Littlehampton Heritage Group

LU/214/20/PL

Empty Supermarket Premises Avon Road Littlehampton BN17 6AT

Drawing Tittle
PROPOSED
ELEVATION D- CENTRA GREEN

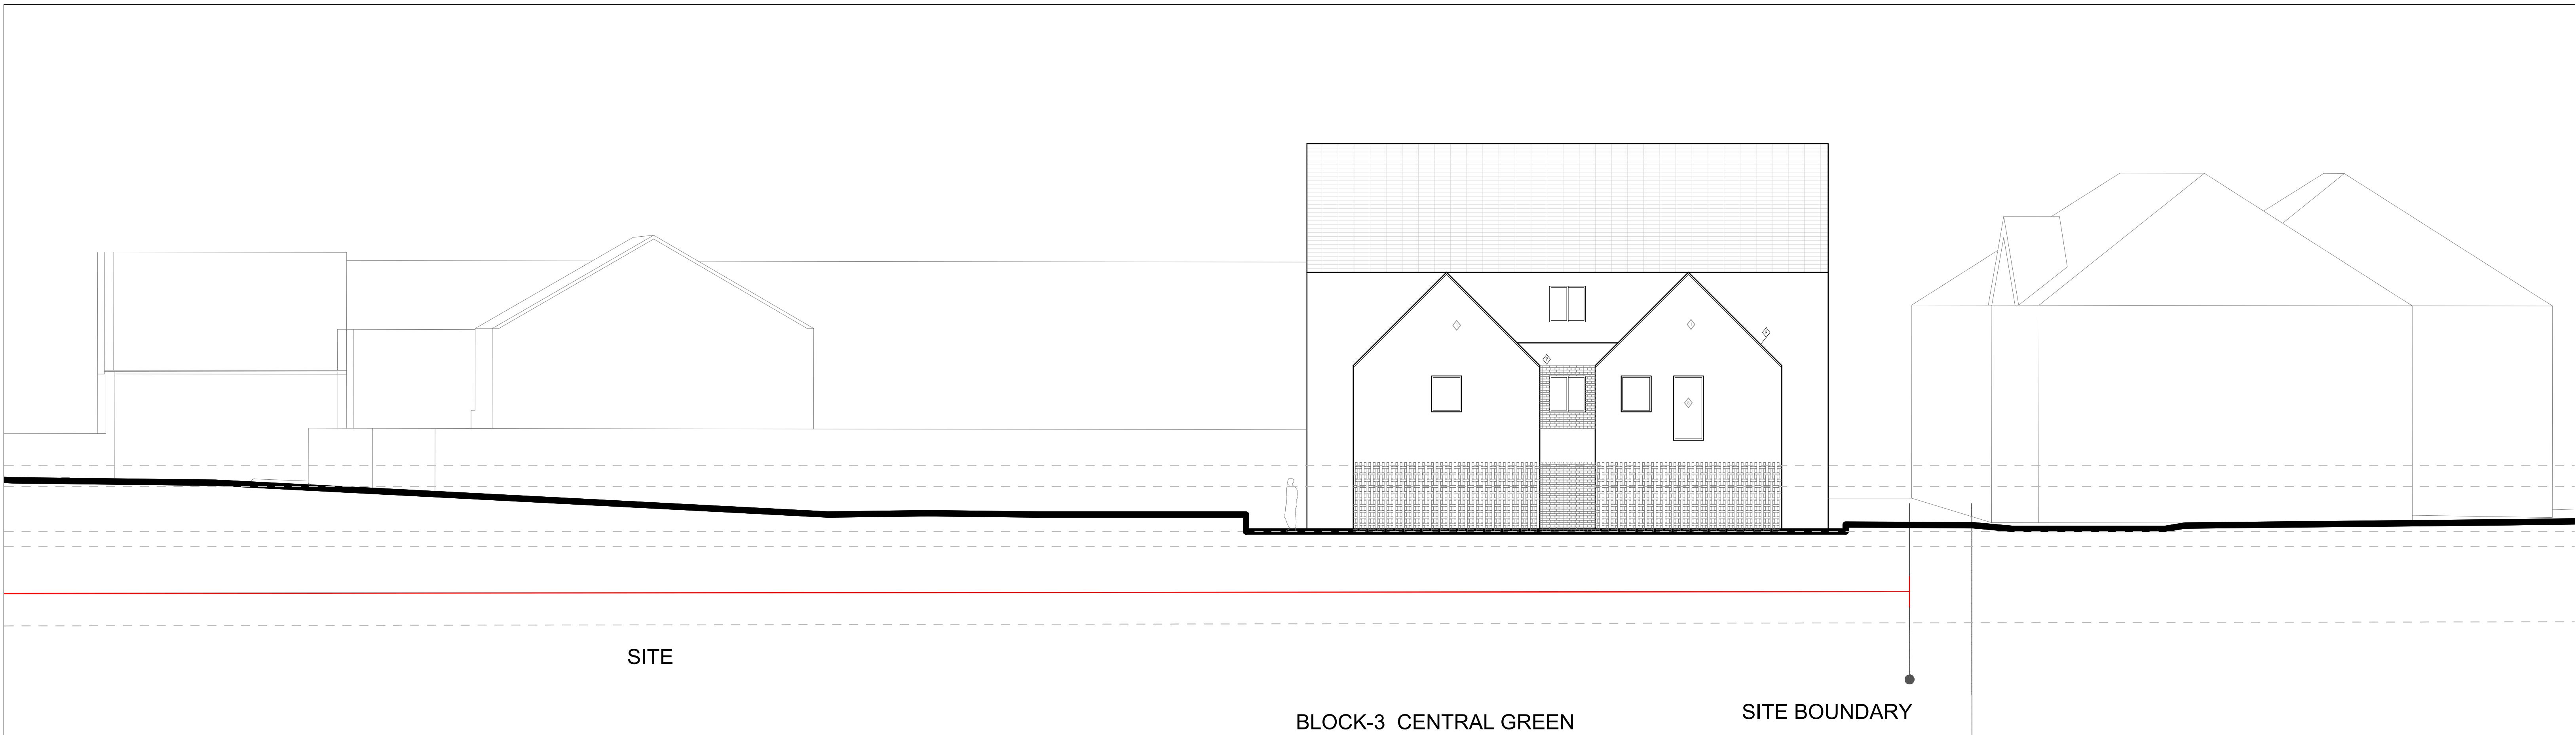
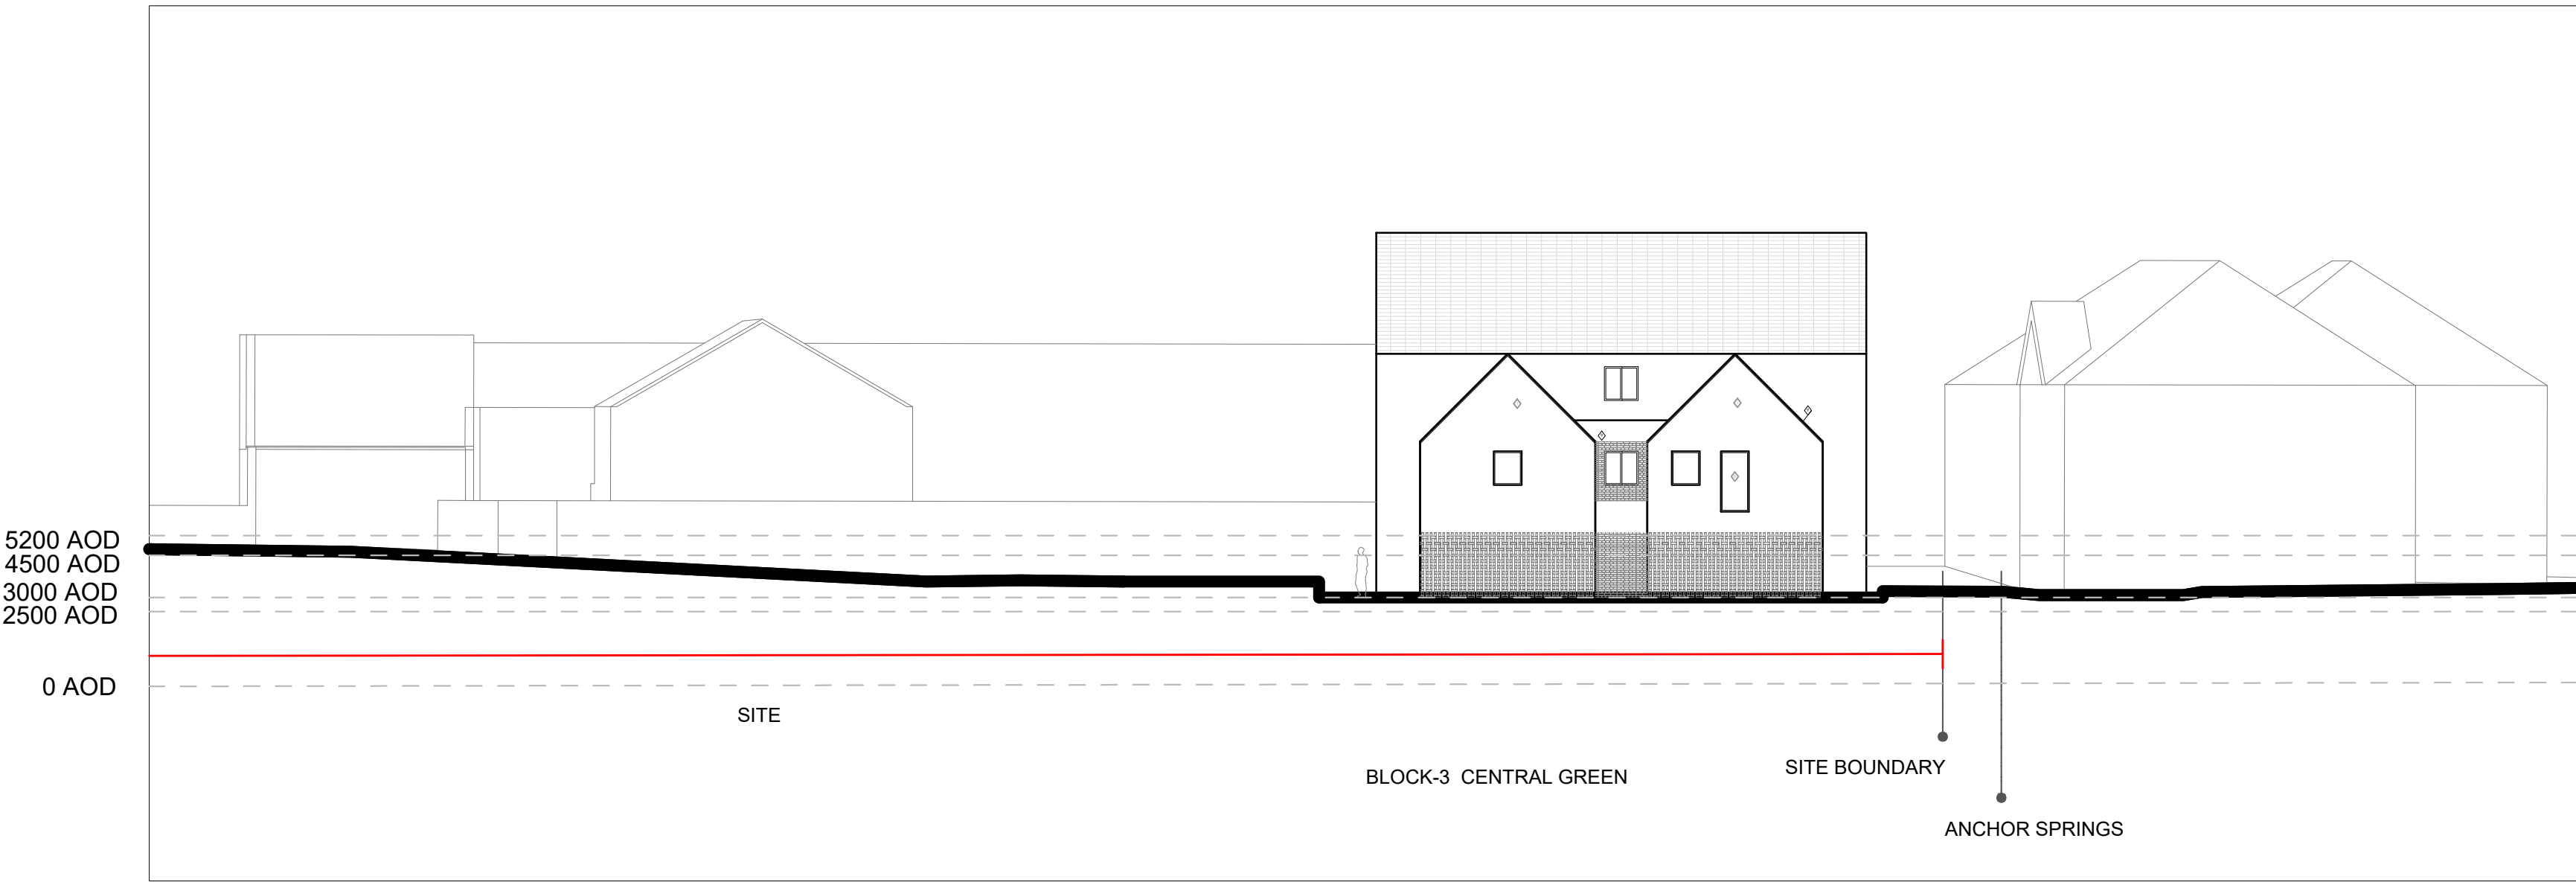
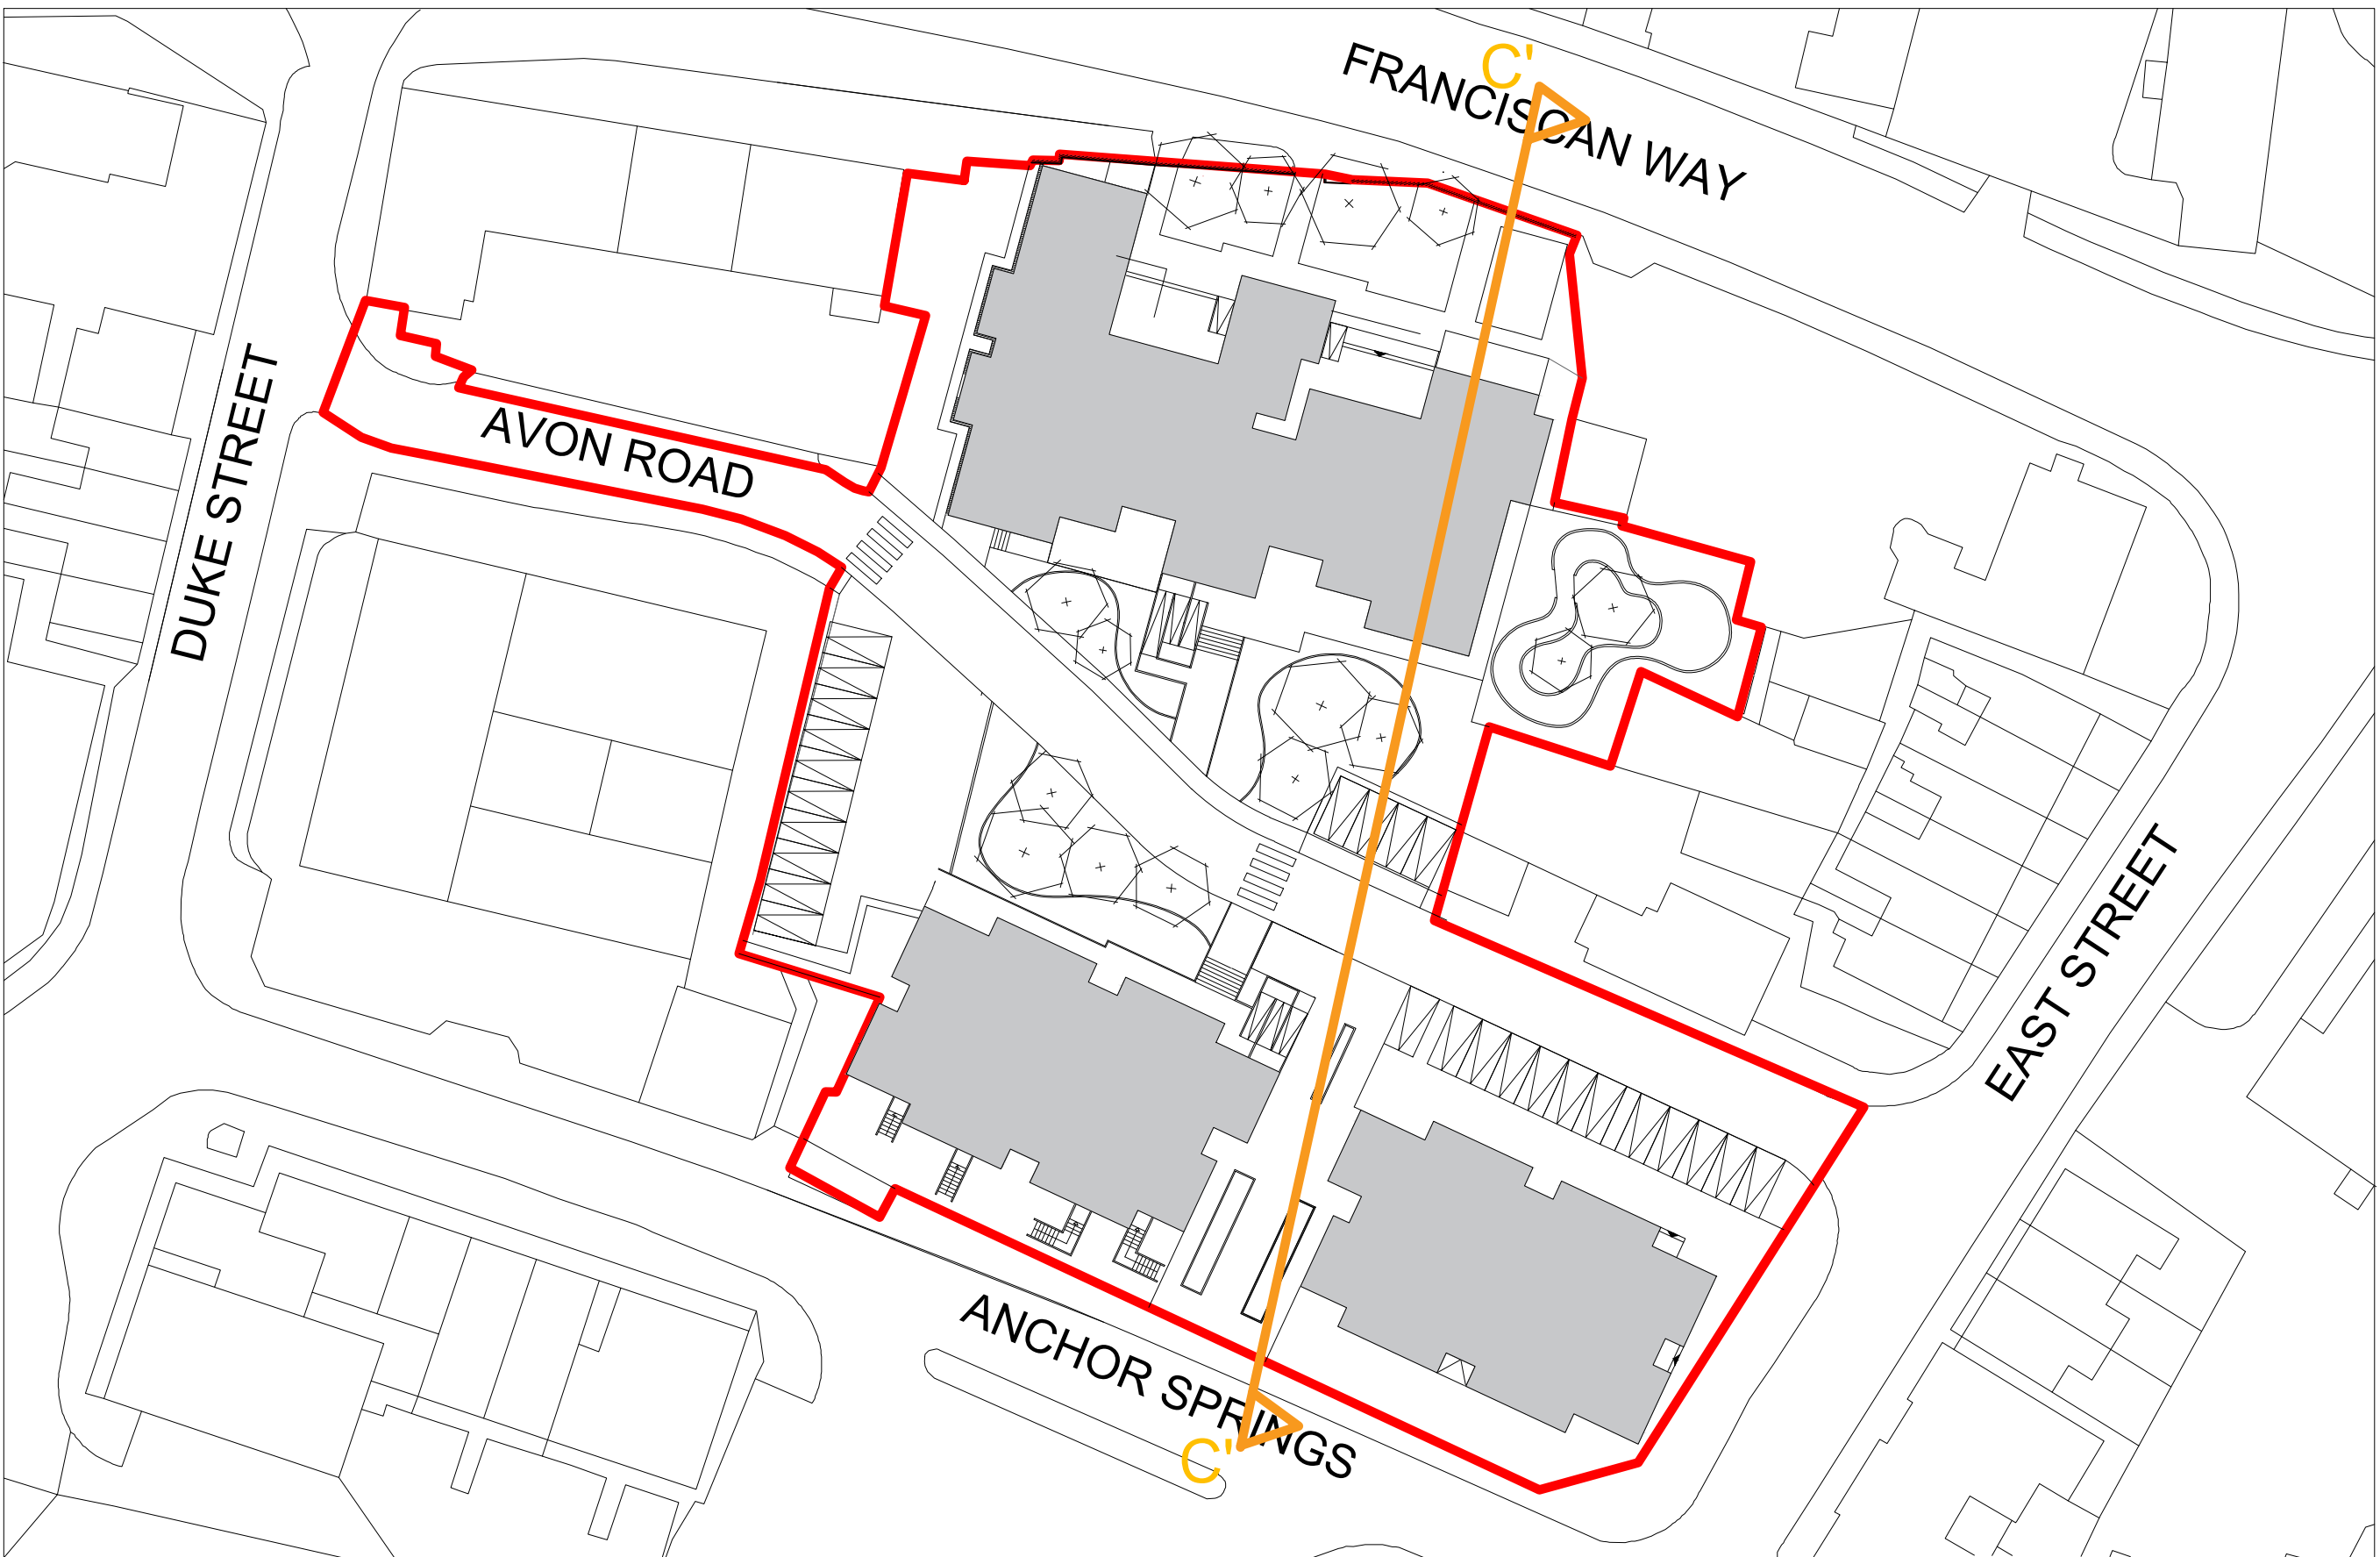
This proposal is on the immediate boundary of the East Street conservation area. We consider the creation of the new blocks of flats, at points higher than the existing supermarket building, to be at great odds with the characteristics of the area. Both in scale and design. It is likely to overwhelm it.

The position and glass fronted slab design of the shops is incongruous with any building they overlook. The Gratwick Arms development and the proximity to the Flint faced Flintstone Centre, should be considered as this looks directly onto them. Plus, for shops, there is no immediate parking nearby for deliveries and loading.
